**Narrabri Gas Project (SSD 6456)
Comment on the Environmental Impact Statement (EIS)**

Narrabri Gas Project (SSD 6456) Detailed comments – DPI Water Recommendations

Figure 3-4 Nominated alluvial aquifer groundwater monitoring bores

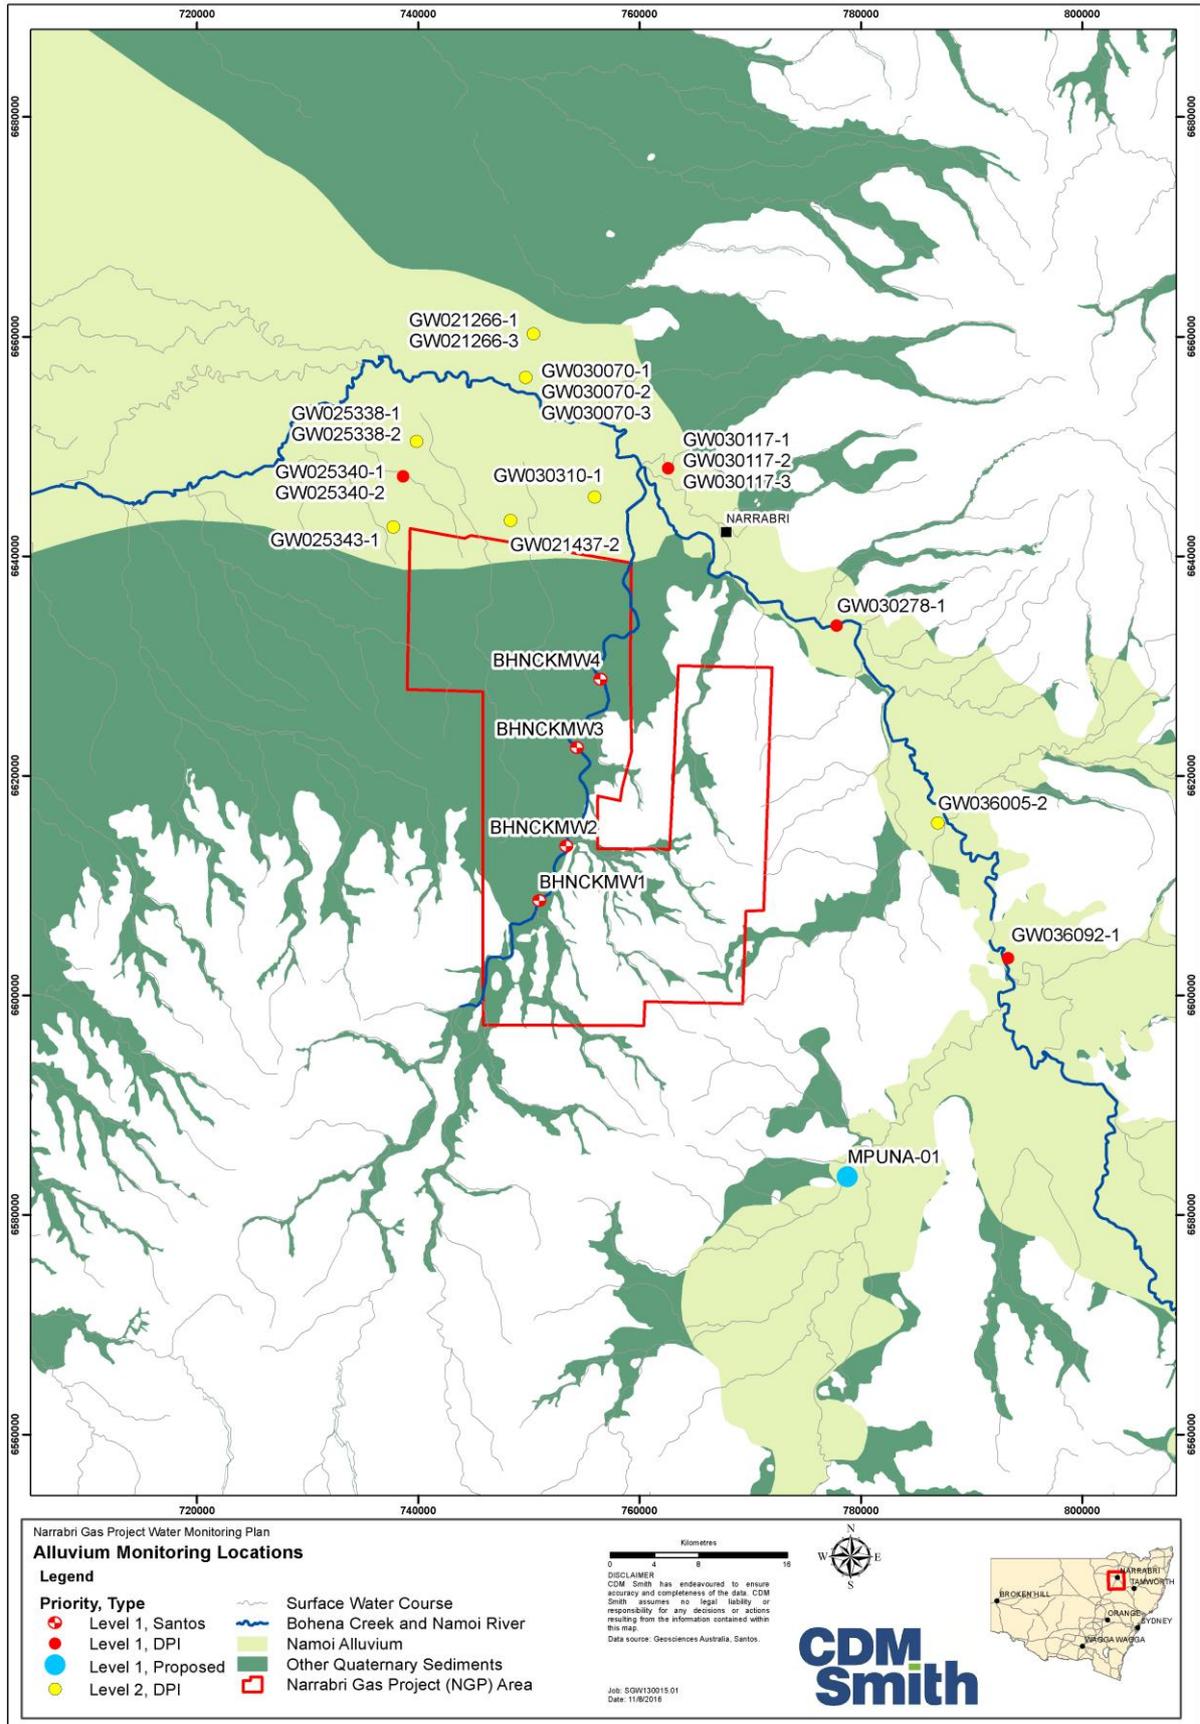
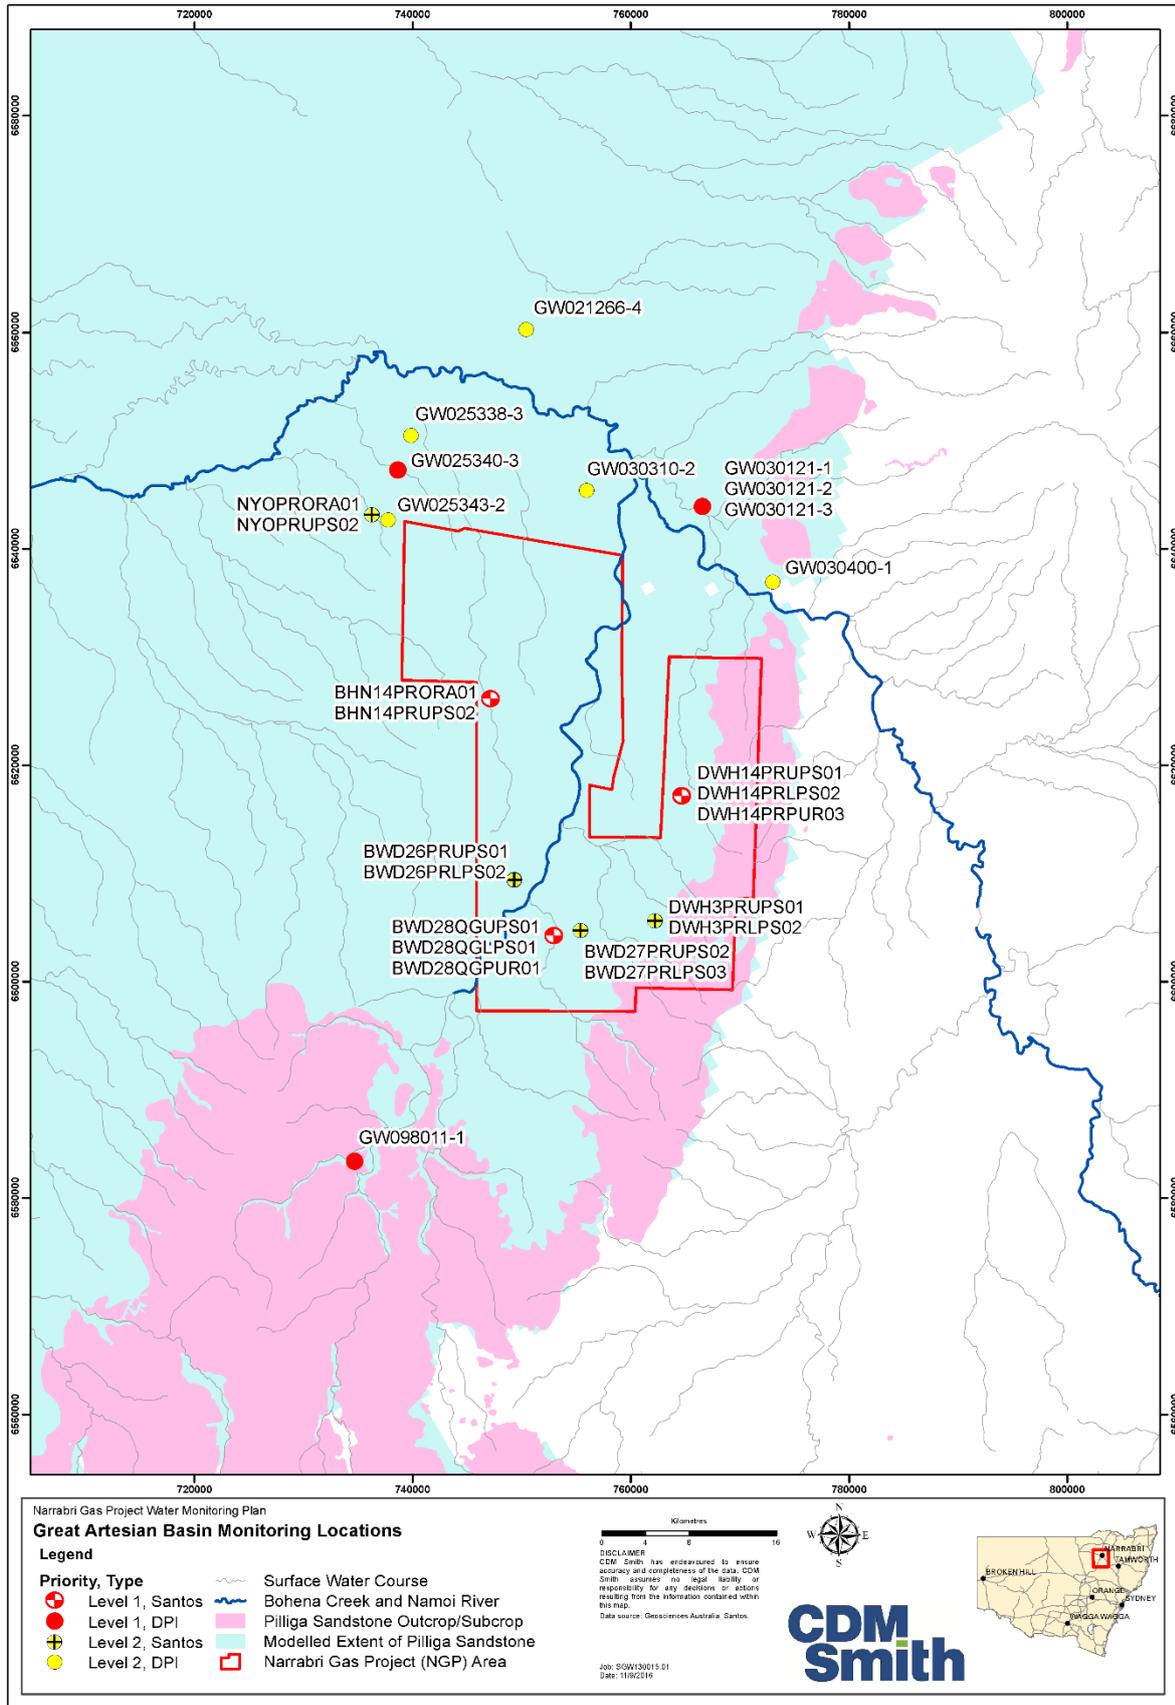
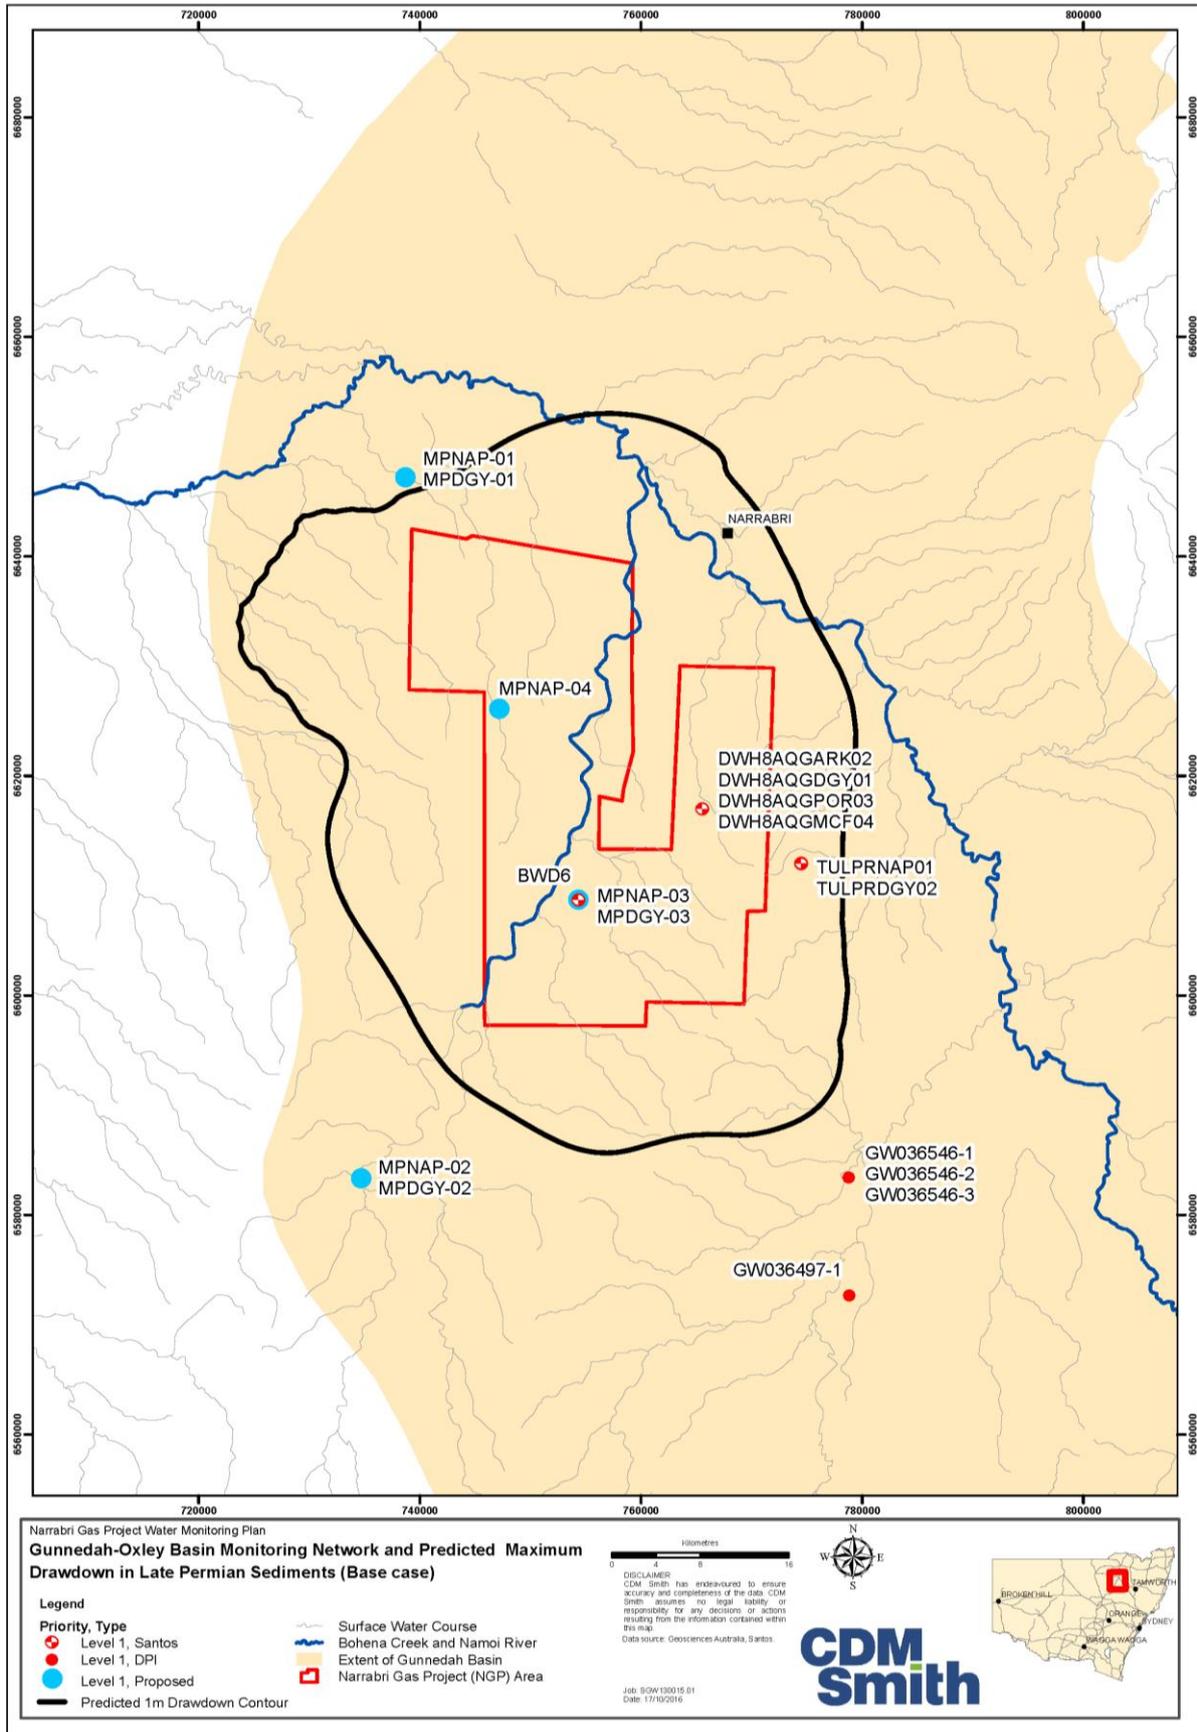
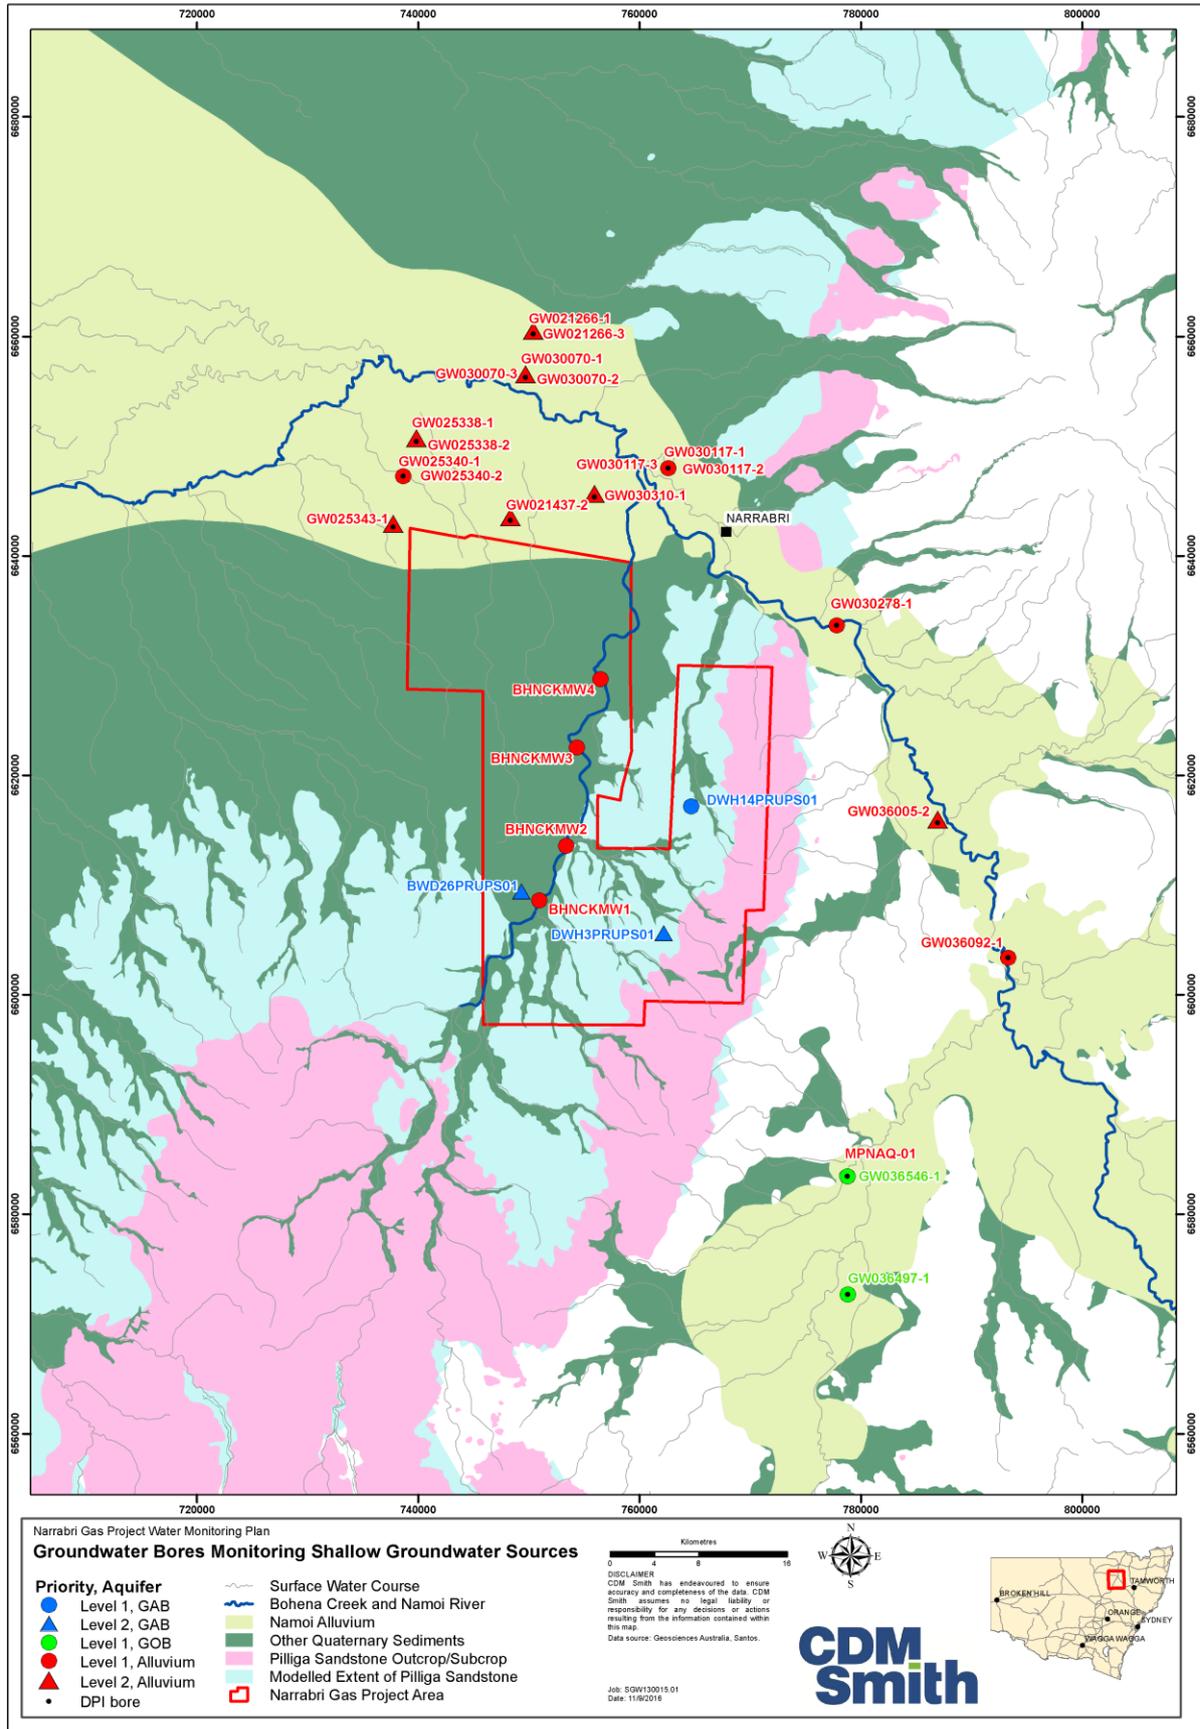
4. In Figures 3-1, 3-2 and 3-3 and Table 4-1 of the Water Baseline Report and Figures 3-4, 3-5, 3-6 and 3-9 and Table B-1 of the Water Monitoring Plan, DPIW has identified 12 government owned

monitoring bores that the proponent has assigned to a geological unit different to DPIW's interpretation (details are given in (Attachment D), the proponent is required to;

- a. justify the geological unit they have assigned to each of the twelve monitoring bores to the satisfaction of DPIW or
- b. amend the relevant sections to include each bore in the geological unit assigned by DPIW, this will result in changes to the assessment of baseline condition that must be addressed by the proponent.
